**Response to Planning application from Hertfordshire County Council (T and CP GDP Order 2015)**

District ref: 6/2021/3172/FULL  
HCC ref: WH/11418/2022  
HCC received: 14 March 2022  
Area manager: Matthew Armstrong  
Case officer: Paul Marshall

51 KENTISH LANE HATFIELD AL9 6NG

Change of use of site (house and garden) from a dwellinghouse (Use Class C3) to a mixed-use as a dwellinghouse (Use Class C3) and for commercial film-making and photographic activities (Sui-Generis)

PROJECT REF	DWG NO	REV
21092	004	E

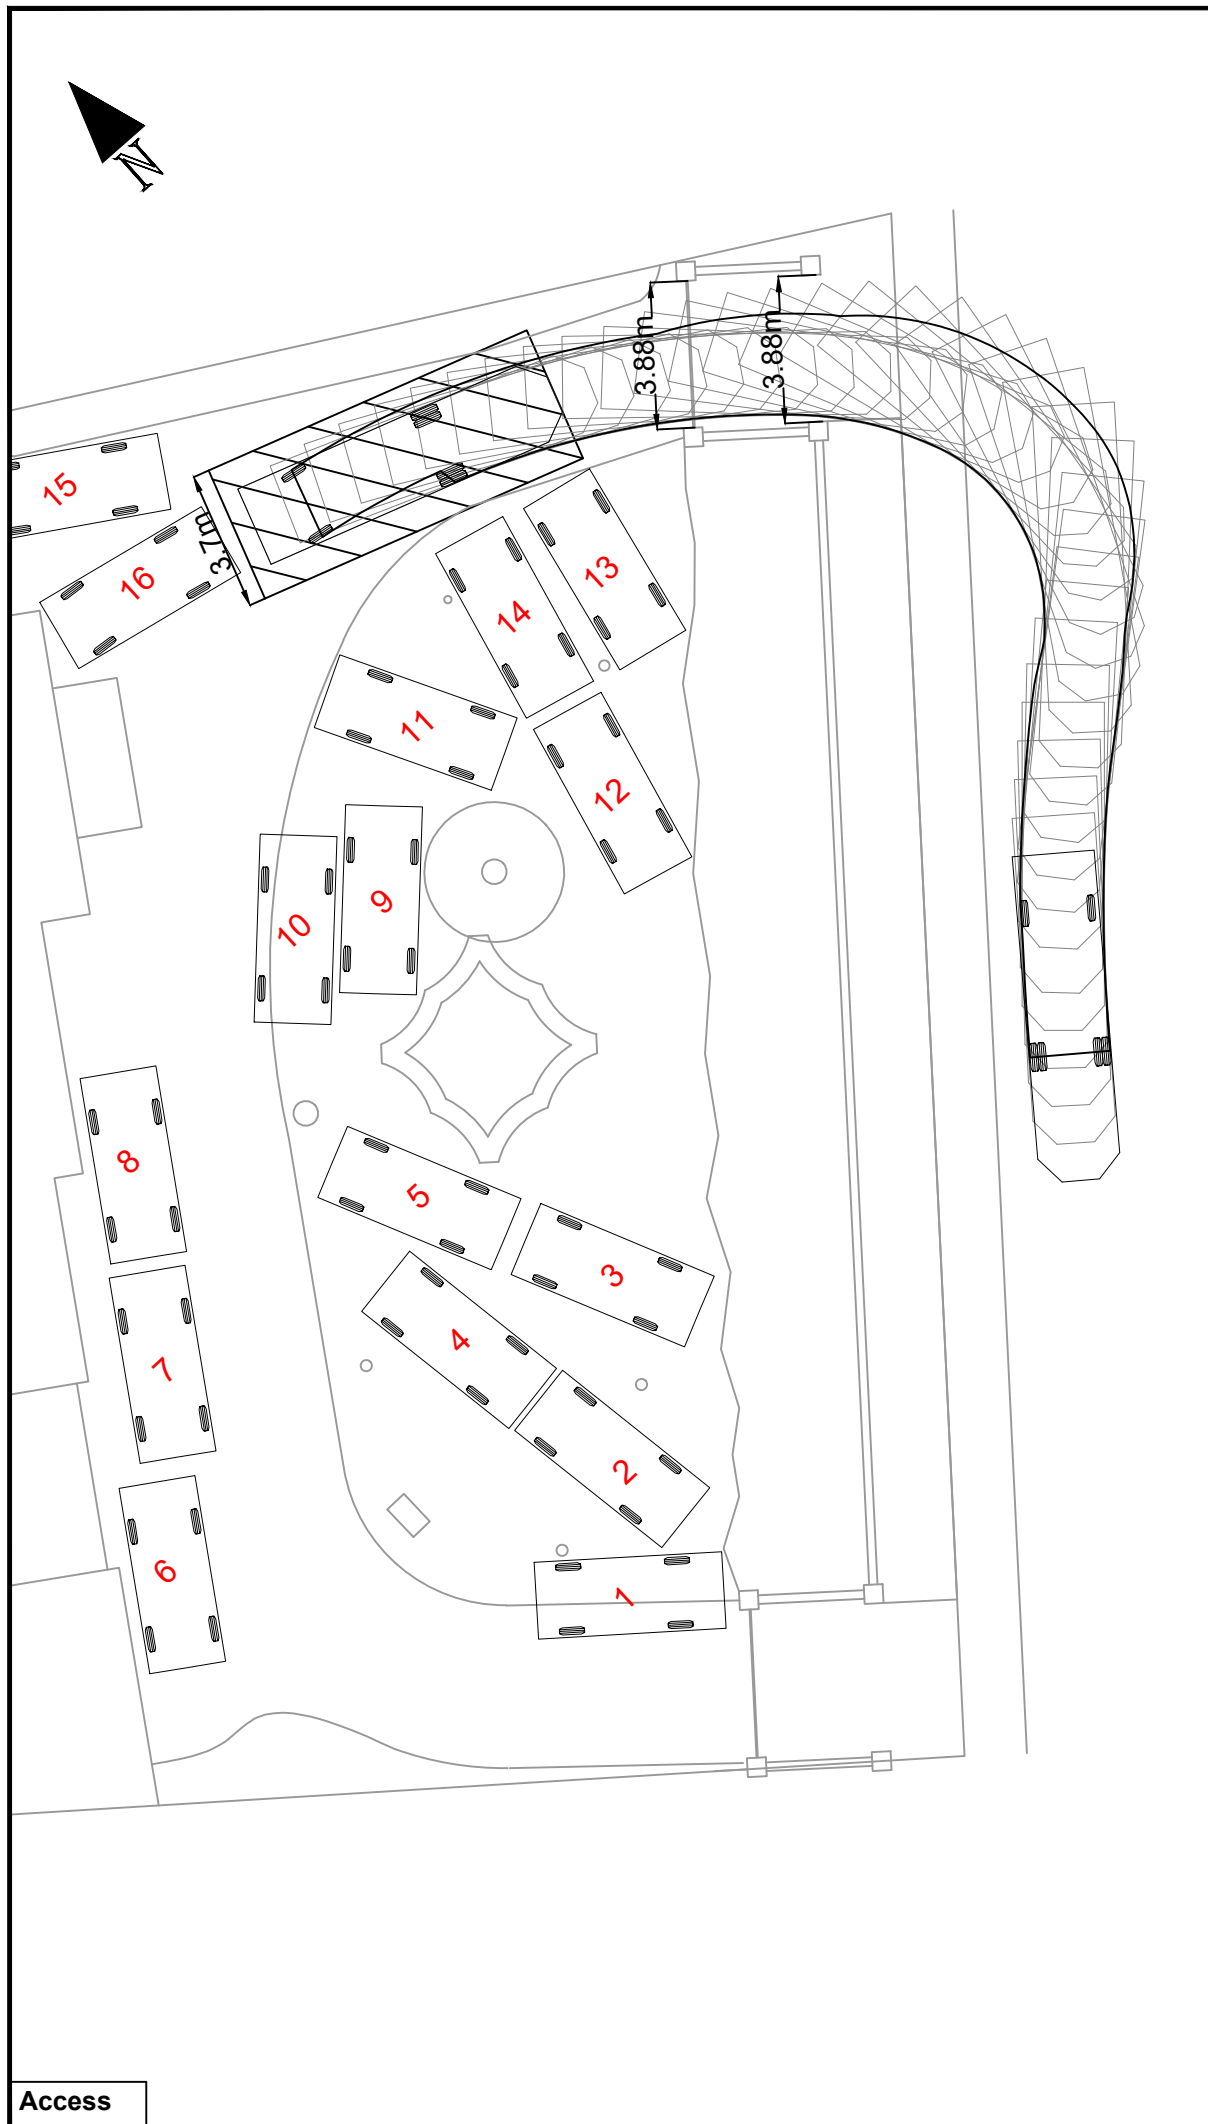
Drawing Nos 21092-004 & 21092-001(Appendix B) has shown that with the assistance of the above stated Traffic Marshall, up to 20 vehicles can be accommodated on site and there will be sufficient room for a minibus / panel van to exit in a forward gear. Drawing 005 Potential Parking Space Arrangements does not show a possible clear route should vehicles need to leave with the maximum limit of 20 on site. For example, should vehicle 6 on the drawing need to leave the site?
